Change of use of No 48 from Licenced Betting Office & Adult Gaming Centre (Sui Generis) to Retail (A1 Shops) & No 50 from Retail (A1 Shops) to Licenced Betting Office & Adult Gaming Centre (Sui Generis).

48 & 50 High Street Littlehampton

Thank you for your internet representation made on 15th September 2019 which has been recorded as '**an objection**' with the comments as follows:

No.50 EXISTING FLOOR PLANS & SHOP FRONT | 1:100

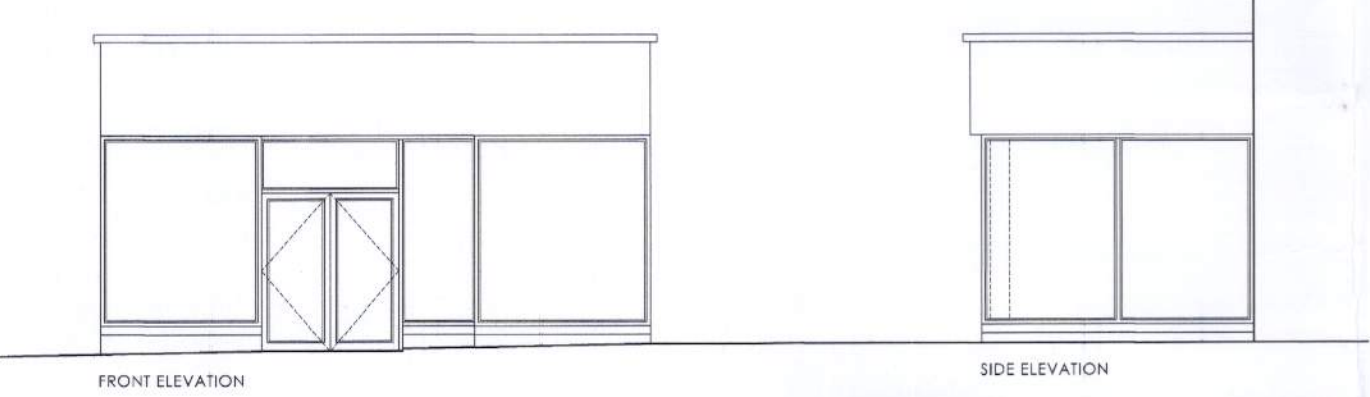
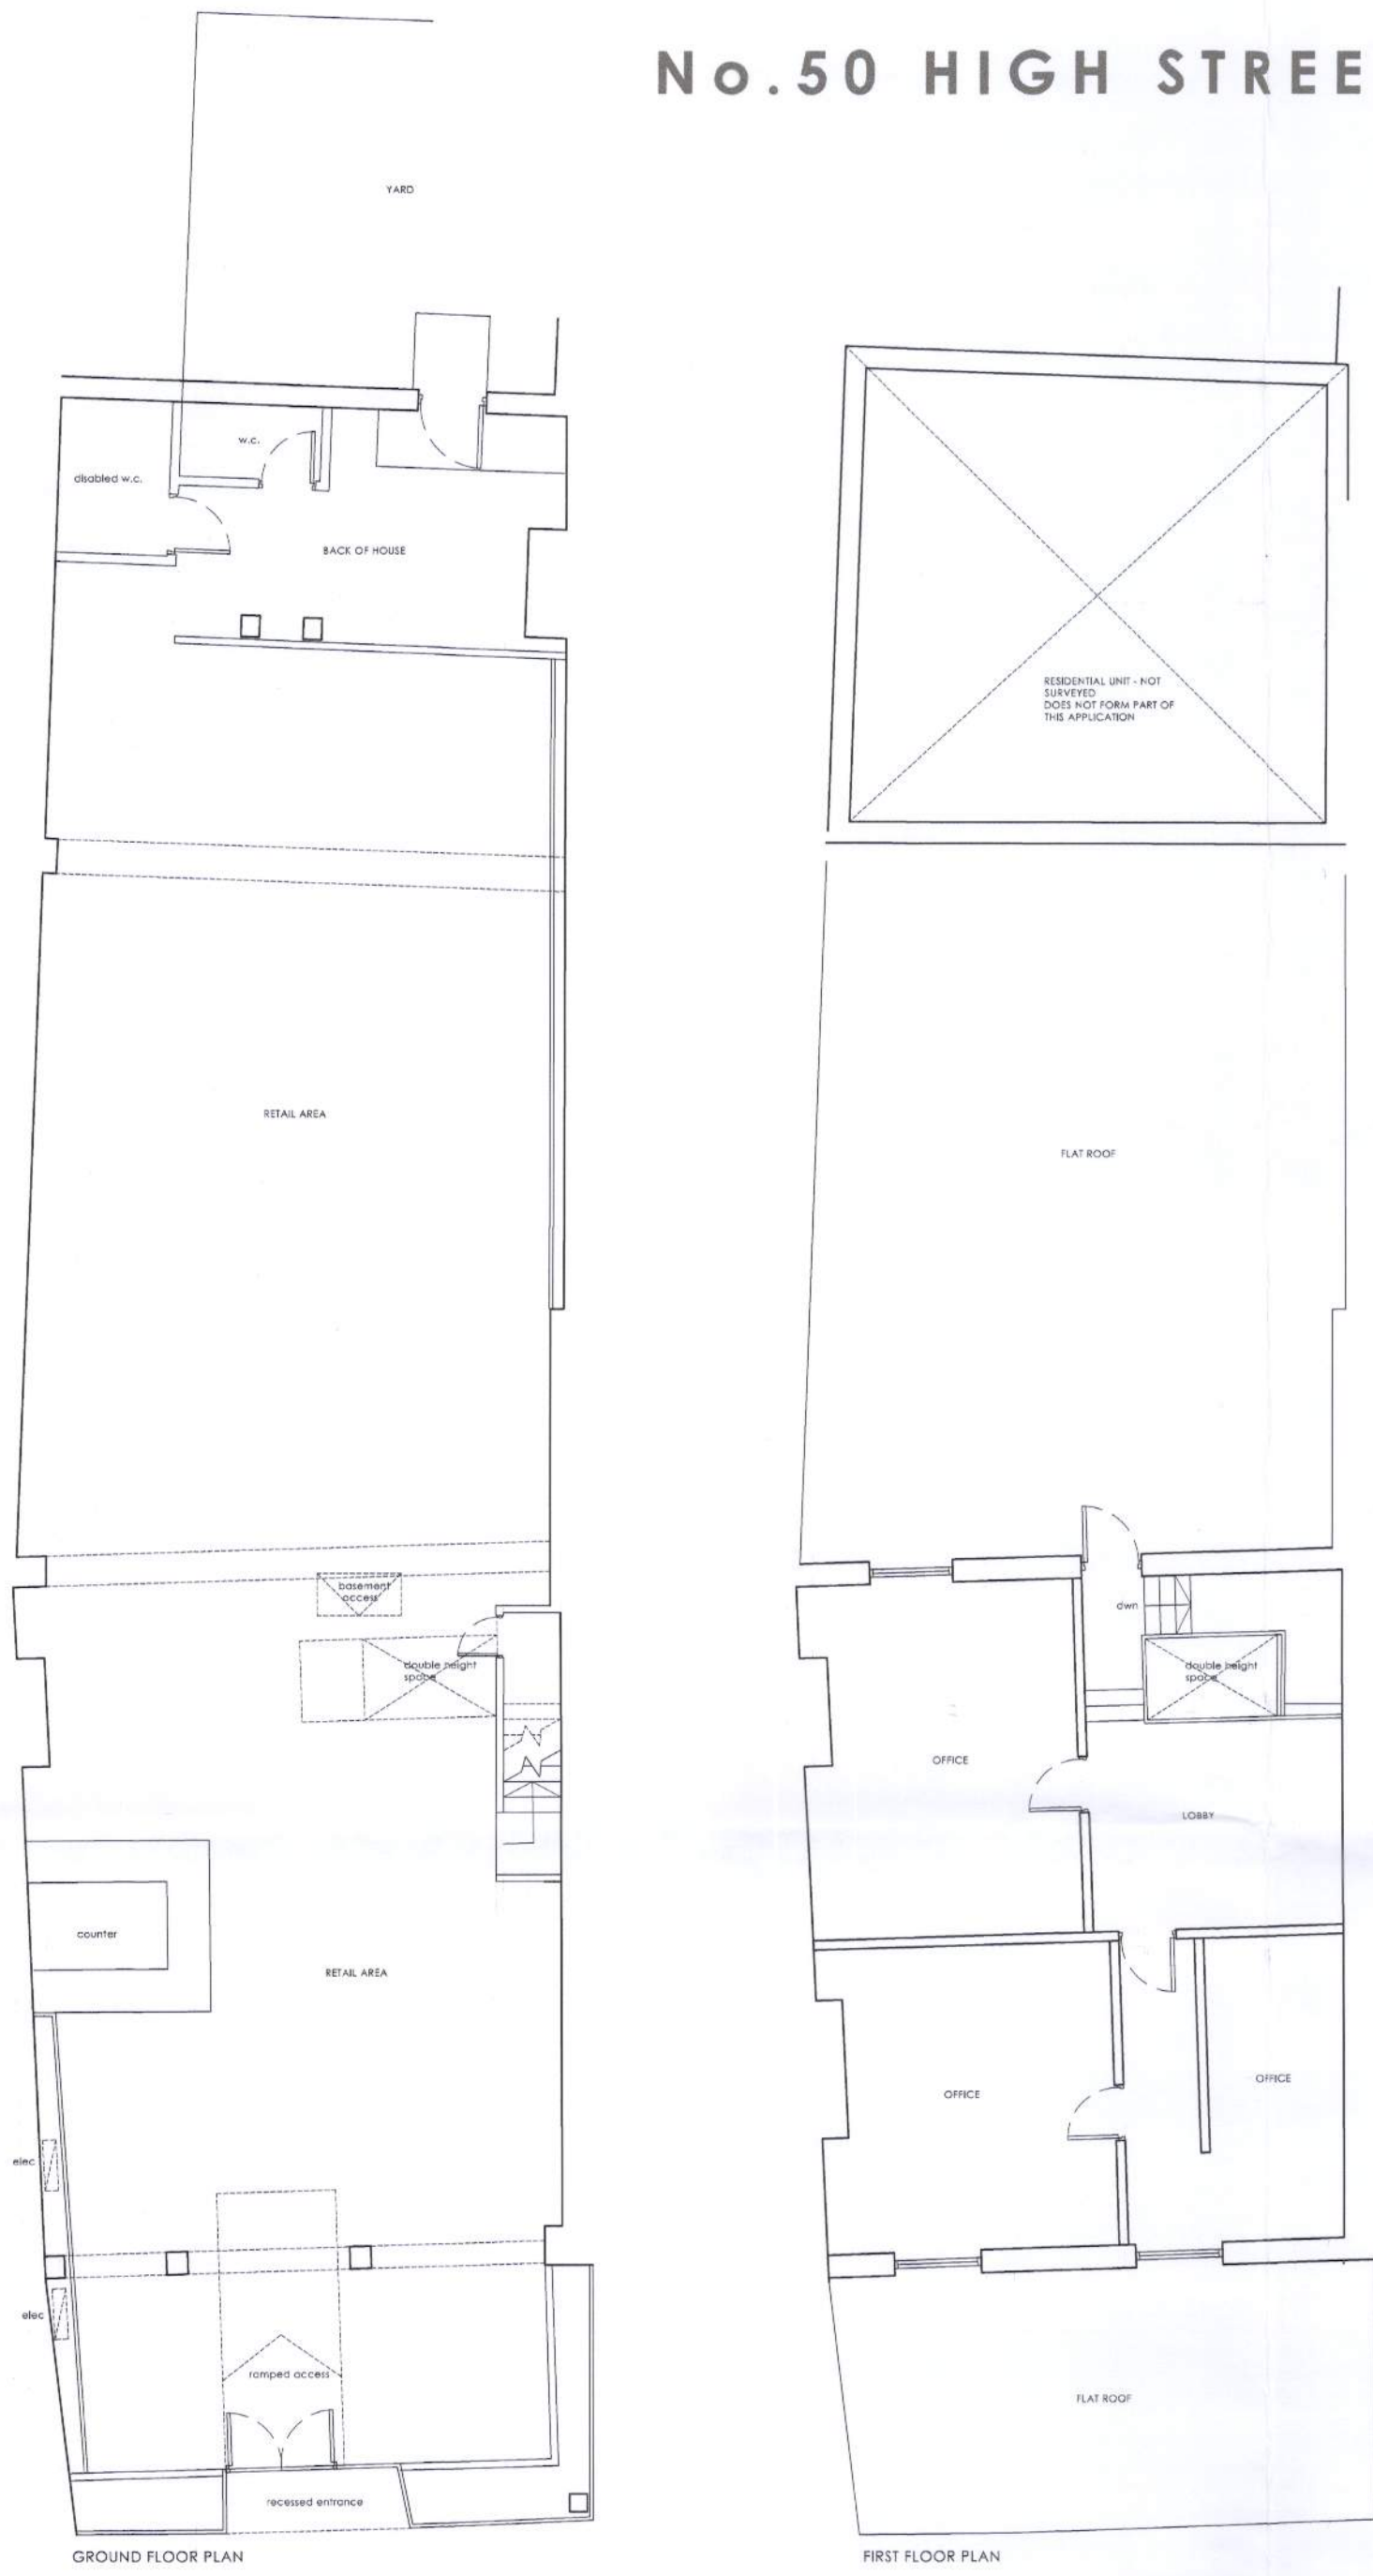
The application omits to mention that no 50 High Street is actually a building of special character. Therefore Arun Local Plan policy HER DM2 comes into play which states that 'proposals for alteration or extension will be expected to relate sensitively to the building or structure and its setting and respect its architectural, landscape or historic interest'. In particular the relationship with no 52 should be considered. That is also a building of special character with interesting features and similar examples in Petworth and Croydon have been listed. There seems to be no proposed visuals of the front of the building enclosed with the application and we would suggest there should be. Policy RET DM1 2b in the Local Plan states that 'provision should be made for a window display, appropriate to a shop front, which is in keeping with the character of the shopping area'.
